MA10/5828

**Environmental Assessment Exhibition – Major Project 09_0205
Expansion of Jones Bay Wharf Marina**

I refer to the Department's letter dated 5 November 2010 seeking NSW Maritime's comment on the Environmental Assessment (EA) for the above project.

Title: EXISTING AND PROPOSED LEASE BOUNDARIES

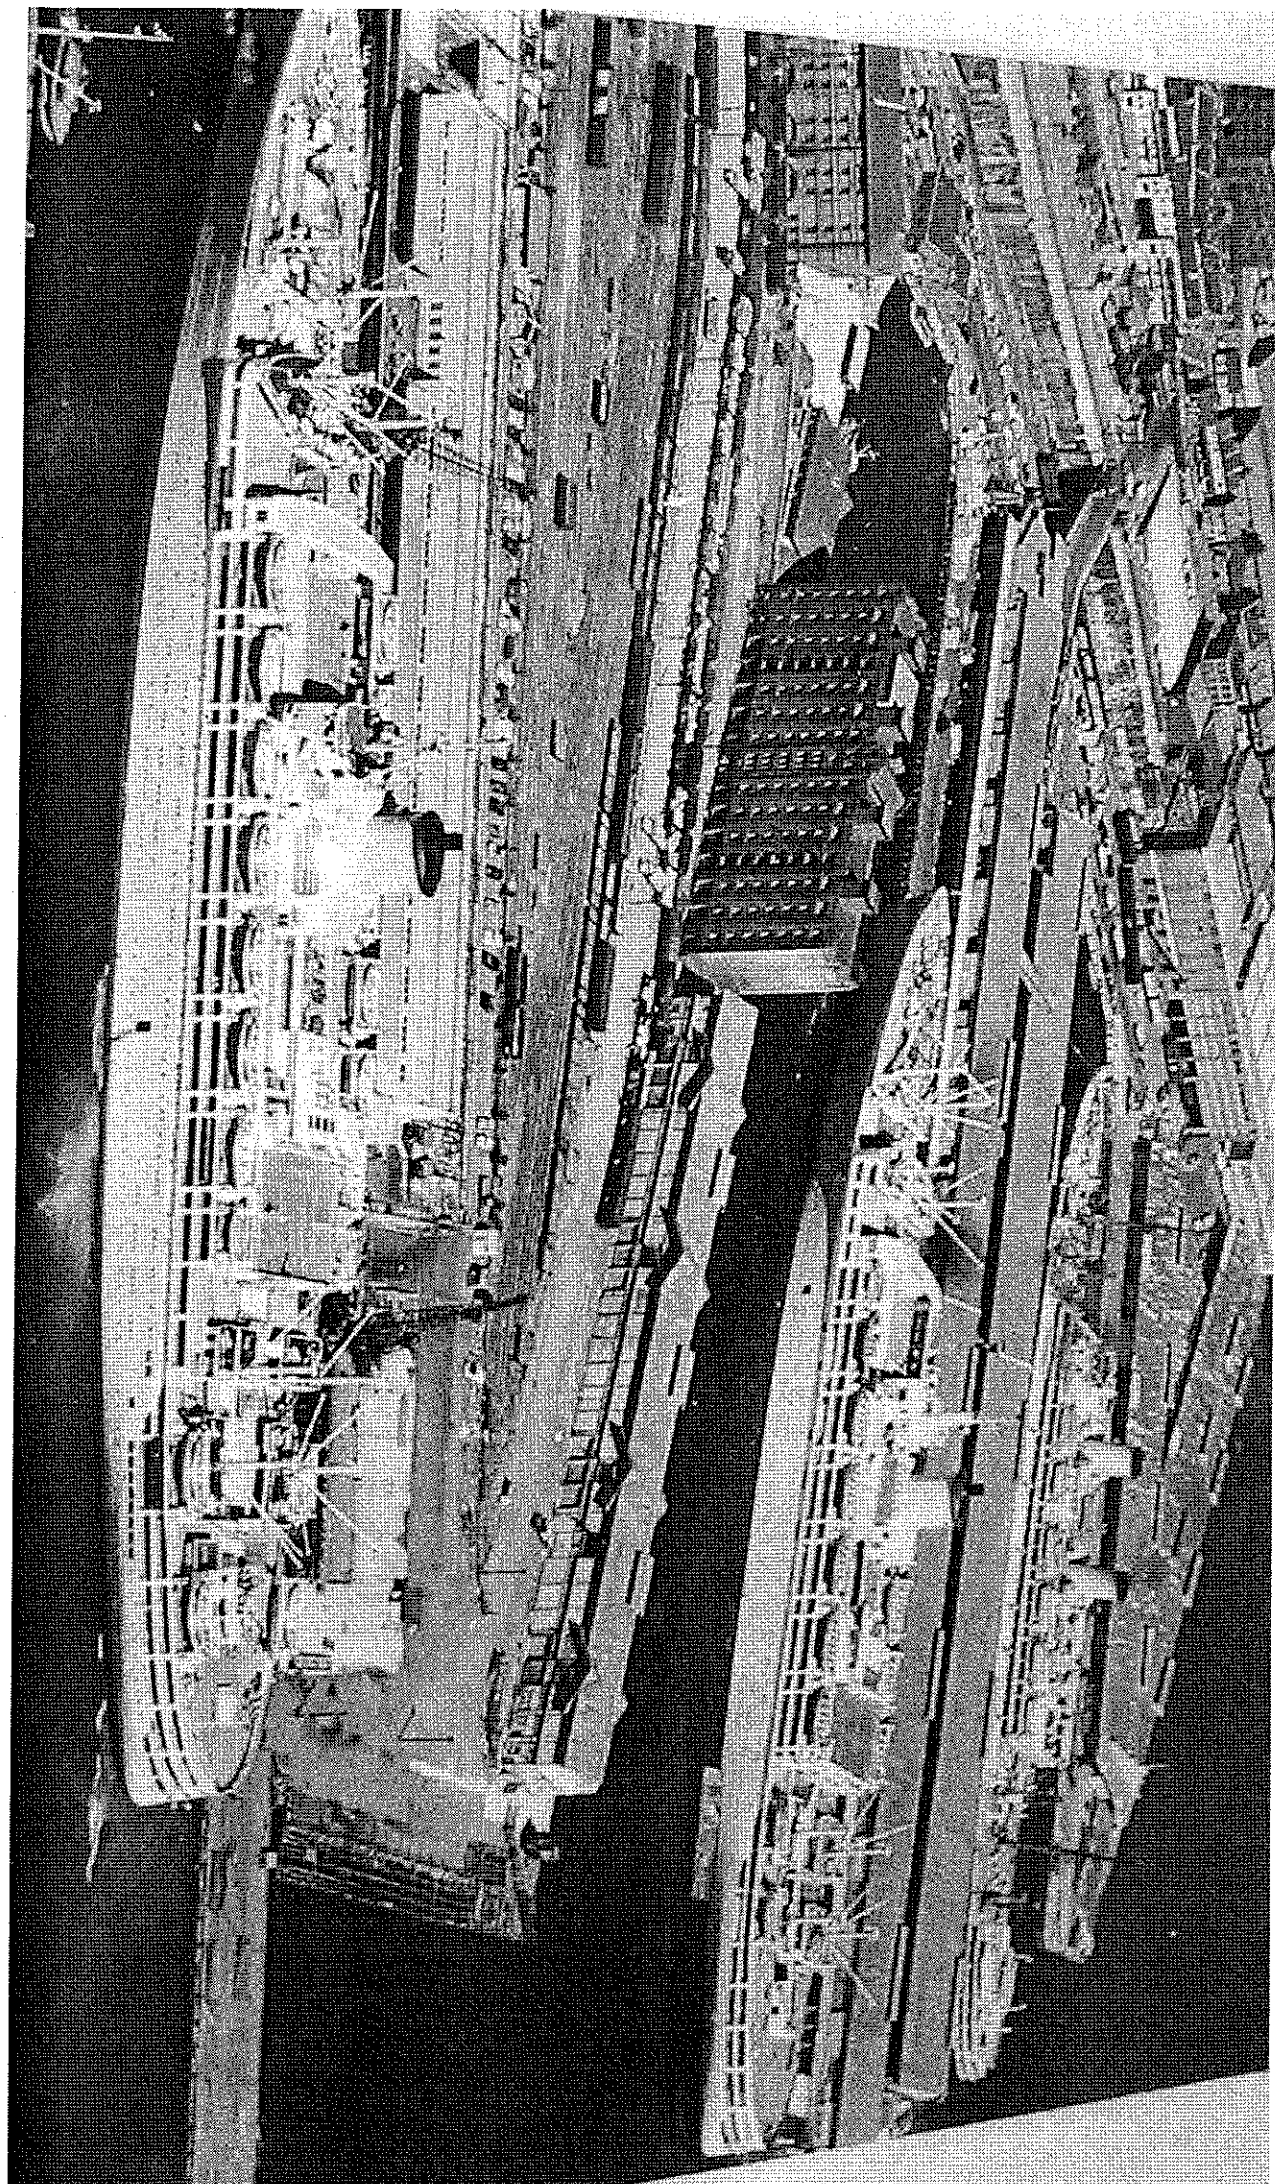
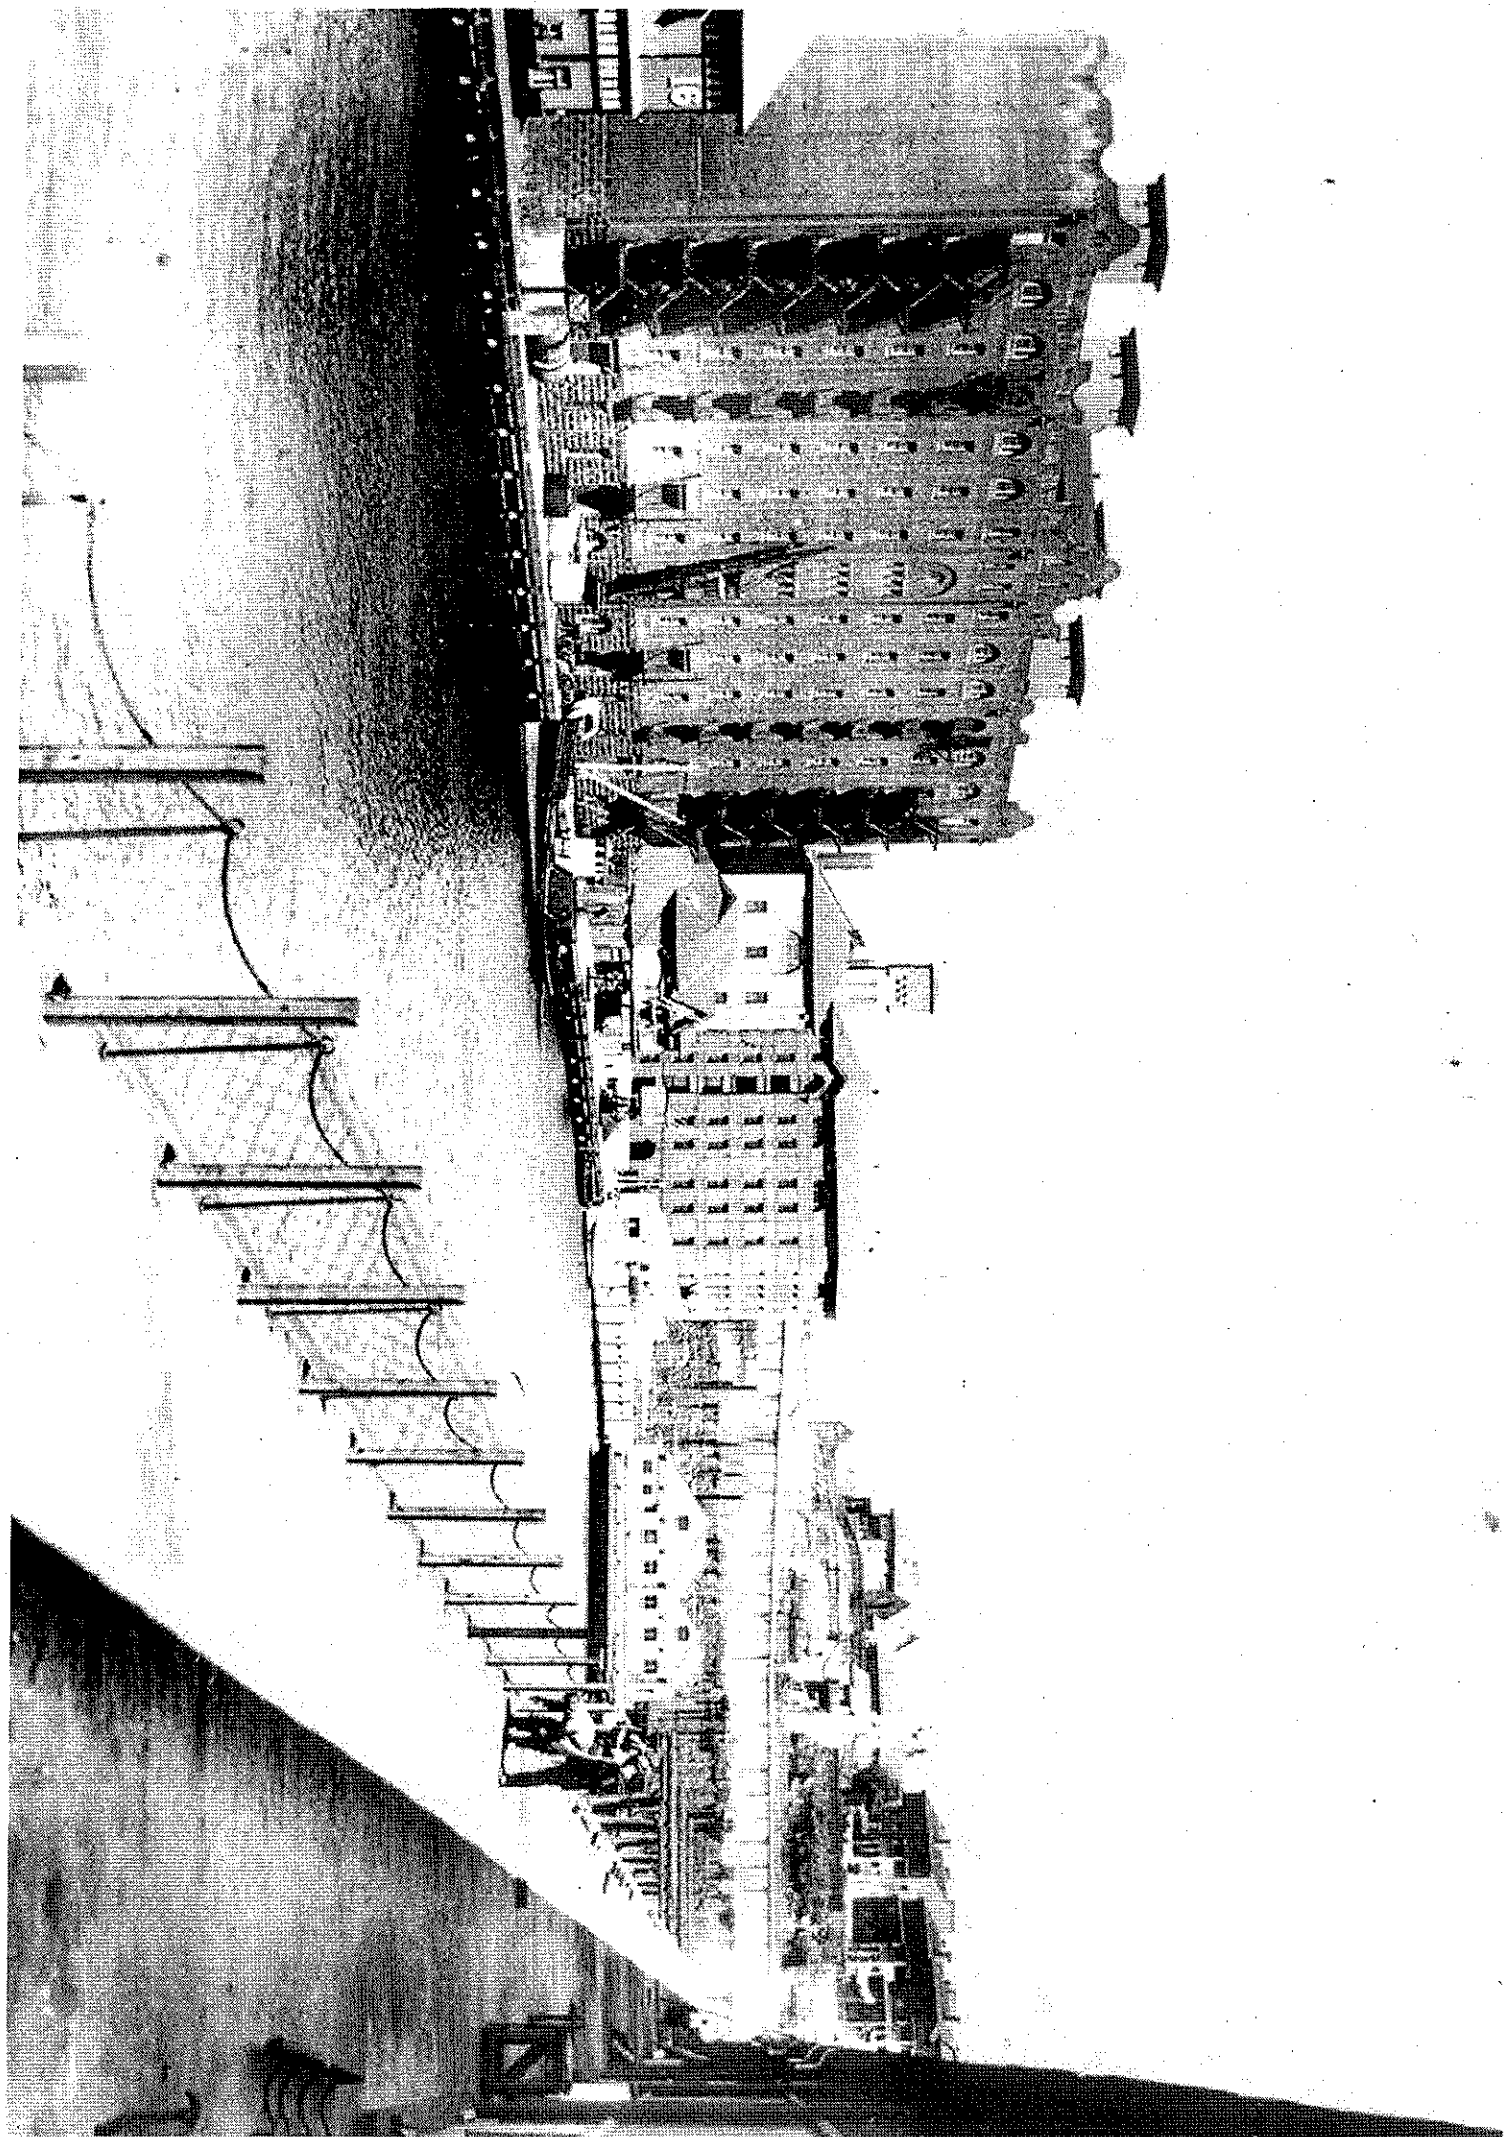
1. The proposed lease boundary shown in Attachment C extends beyond what is required to facilitate this development and will alienate the use of the waterway around Darling Island to the east. This plan should be excluded from any approval (if granted) and the applicant should be advised to discuss leasing arrangements directly with NSW Maritime.
